CITY OF ALBUQUERQUE

July 22, 2016

Re: Construction Seminars Renovations
7915 Prospect Ave NE
Traffic Circulation Layout
Architect's Stamp 07-20-16 (H17D104)

**CONSTRUCTION SEMINARS**  
**RENOVATIONS**  
4915 PROSPECT AVENUE NE, ALBUQUERQUE, NM 87110

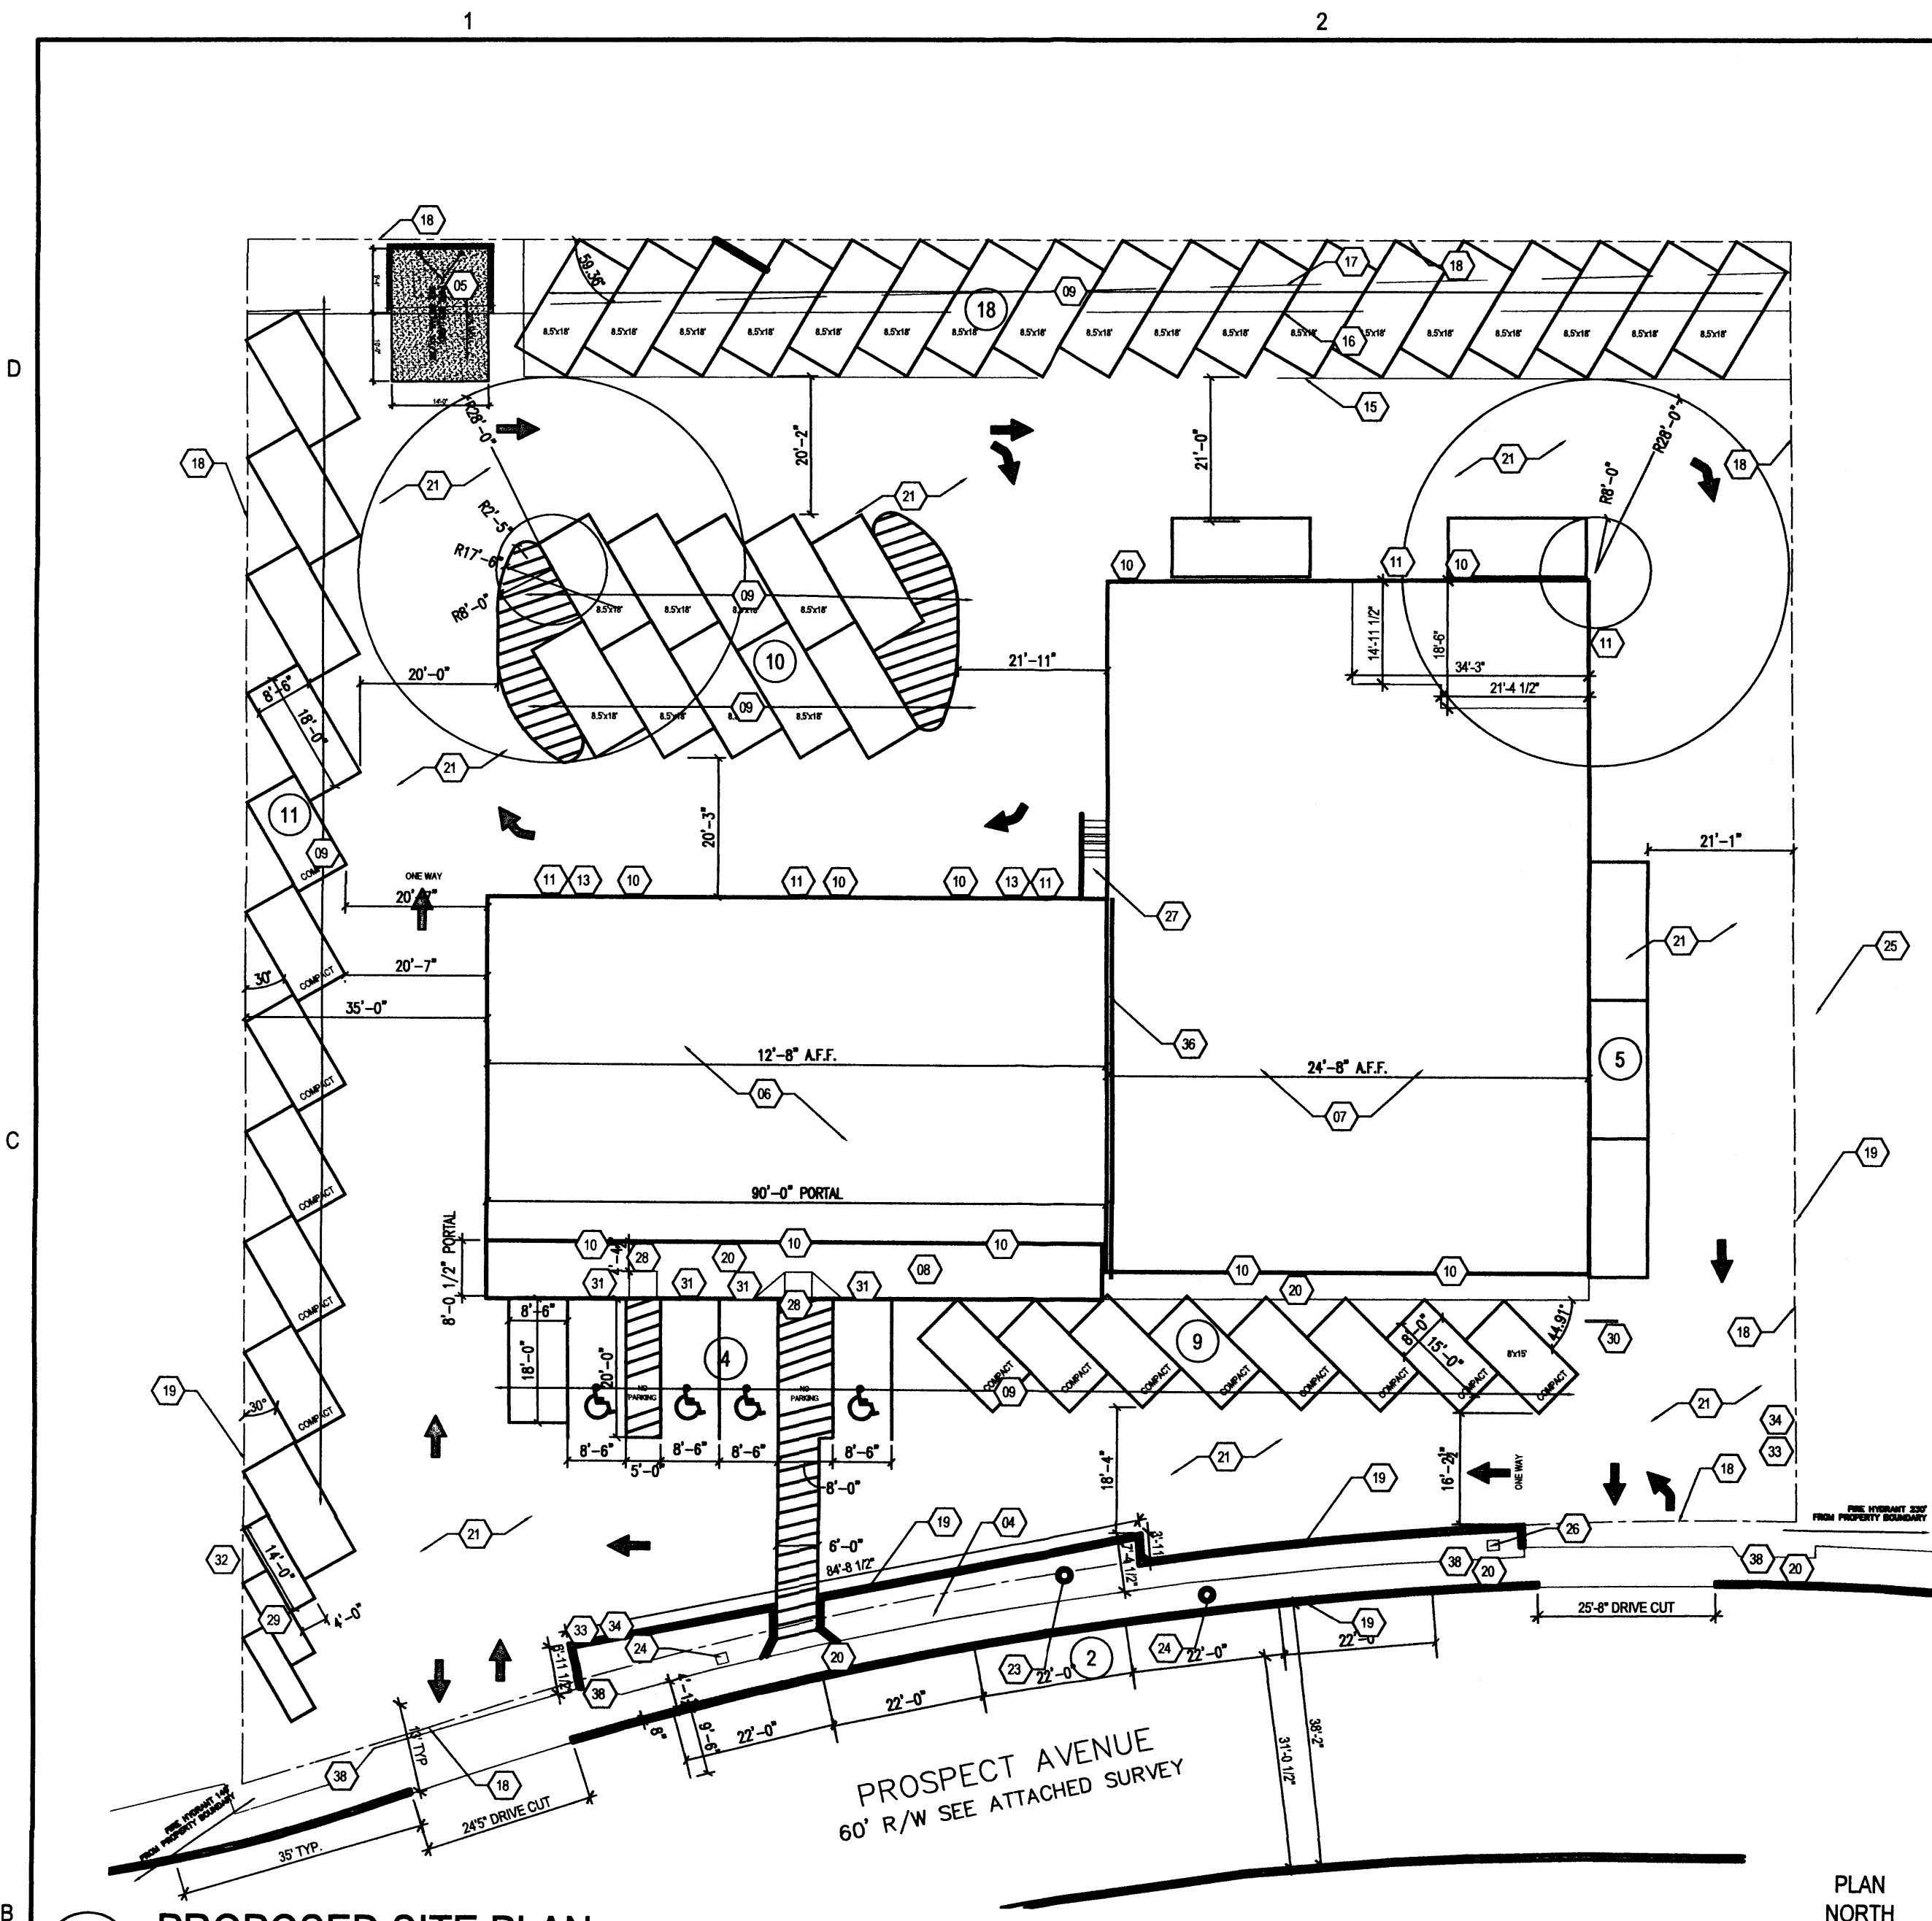
1. Please show a vicinity map showing the location of the development in relation to streets and well known landmarks.
2. Identify the right of way width, medians, curb cuts, and street widths on Prospect Ave NE.

3. The 6 ft. wide ADA accessible pedestrian pathway required from the public sidewalk to the building entrances must be clear of any curb lines. Please clearly show this pathway and provide details.

4. Provide a detail of all ADA accessible ramps onsite.
5. Provide dimensions of motorcycle parking. (Zoning Code, 14-16-31, C.)
6. One-way vehicular paths require pavement directional signage and a posted "**Do Not Enter**" sign at the point of egress. Please show detail and location of posted signs.

7. Please provide a sight distance exhibit (see the *Development Process Manual, Chapter 23, Section 6, Part B.12 Visibility for Driveways*).
8. Please add the following note to the clear sight triangle: "Landscaping and signage will not interfere with clear sight requirements. Therefore, signs, walls, trees, and shrubbery between 3 and 8 feet tall (as measured from the gutter pan) will not be acceptable in this area."

9. Please specify the City Standard Drawing Number when applicable.
10. Add keynote 11 to all overhead garage doors.
11. Provide conformation from zoning the amount of parking required and provided is correct.

12. Clarify the limits of the portal that covers the front walkway.

13. Show the existing property lines.
14. Please add a note on the plan stating "All improvements located in the Right of Way must be included on the work order."

15. Show the 3 curbside parking spaces called out on the parking total requirements. If On-street parking credit is required please follow item to request On-Street parking.
